Recommendation Report for Planning Permission for Works or Extension to a Dwelling

REF NO: M/37/18/HH

LOCATION: 7 Alleyne Way
Elmer
Middleton-On-Sea
PO22 6JZ

PROPOSAL: Single storey extensions to East, South & West elevations & loft conversion (resubmission following M/126/17/HH).

Drawing Title:
PROPOSED FLOOR PLANS AND ELEVATIONS

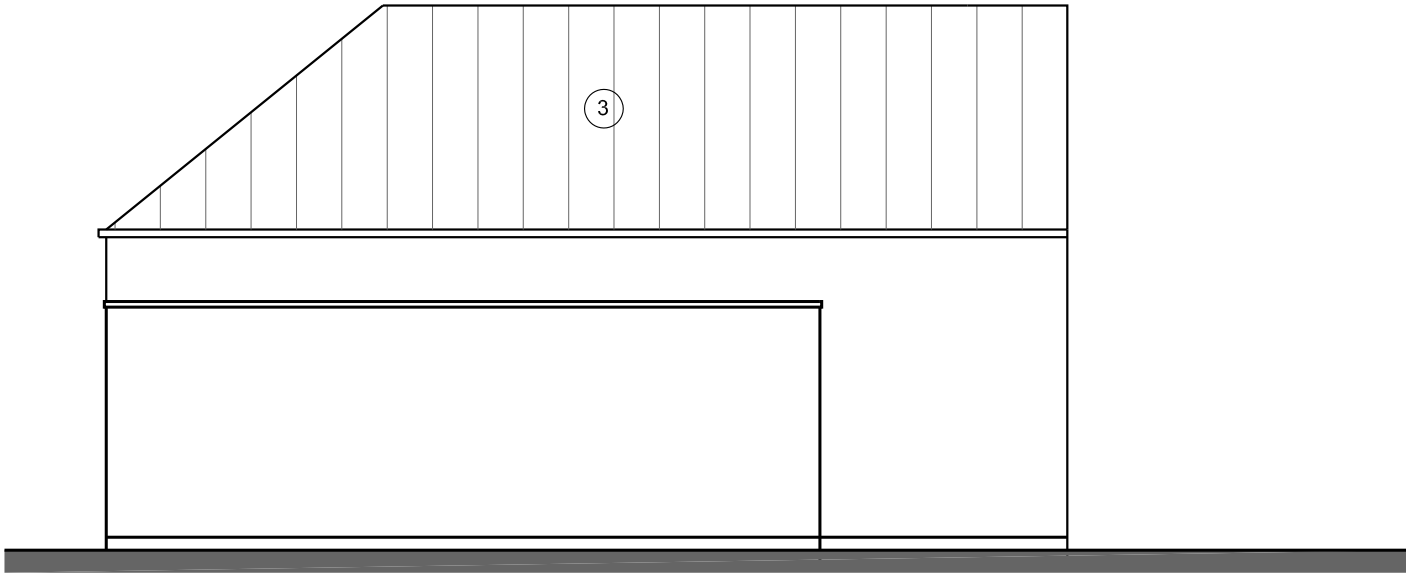
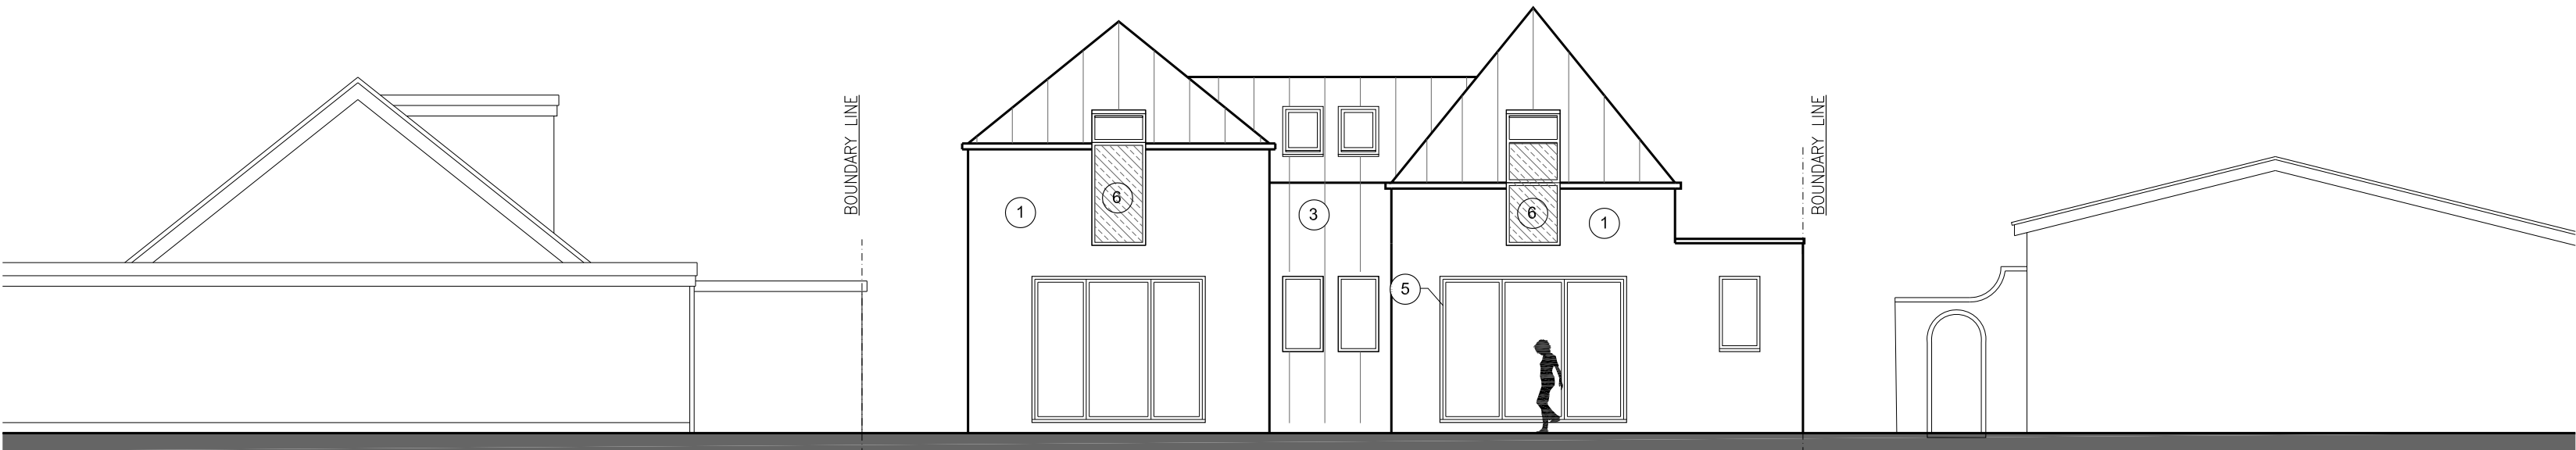
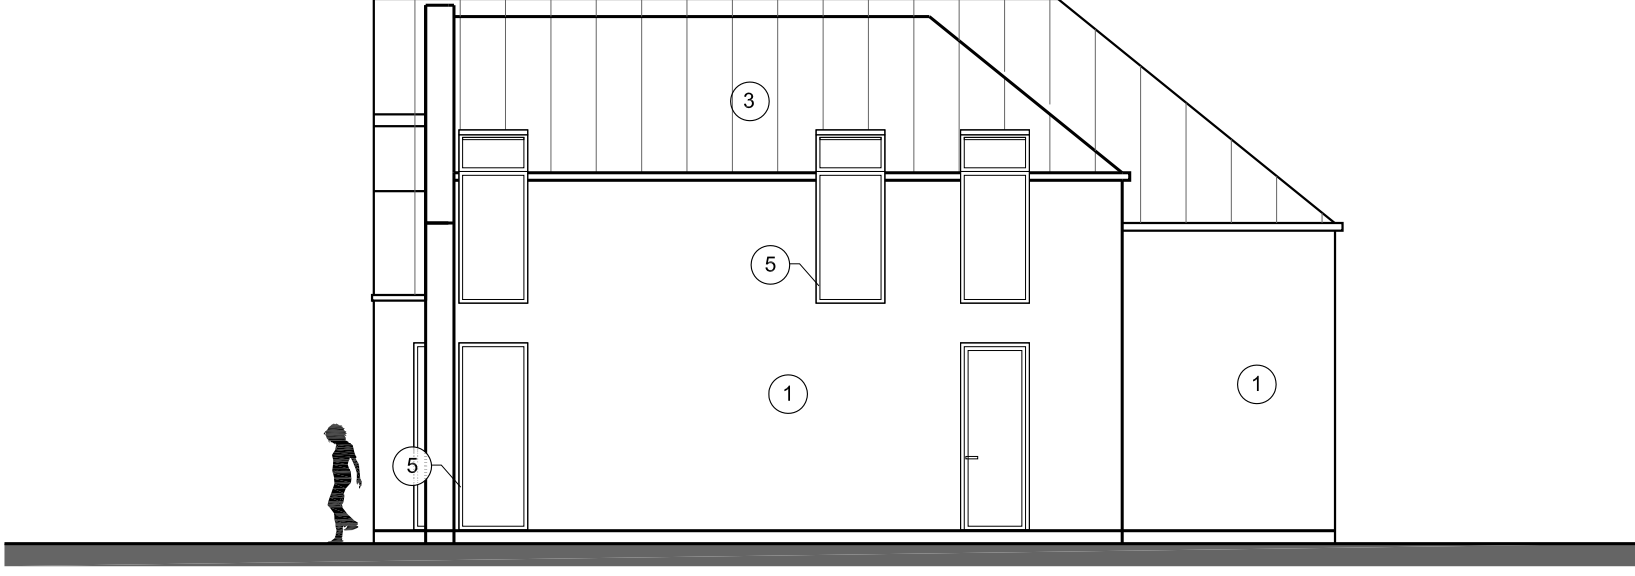
The foot print of the building will extend no further forward or back than the existing. The first floor elements will be 1.5 m higher than the existing roof at the ridge and 1 m higher at the eaves. There is a window in the side elevation of the bungalow to the north, 9 Alleyne Way, which faces the application site but having regard to the relative positions of the existing property to this bungalow and the distance between this window and the eaves (6 m) and ridge (8m) of the new roof on number 7 there will a minimal impact in terms of overshadowing and outlook. There is a dormer window on the side roof slope of the property to the south facing onto the application site. The distance between this dormer and number 7 is 7 m. Due to the orientation and separation distance there will be no loss of light or outlook to this window. Three windows are proposed at first floor in the side elevation opposite this dormer. However they are secondary windows to bedrooms which have principal windows facing west and east and therefore could be subject to a condition to ensure they are glazed with obscure glass.

- 3 The windows on the south elevation at first floor level shall at all times be glazed with obscured glass and fixed to be permanently non-opening.
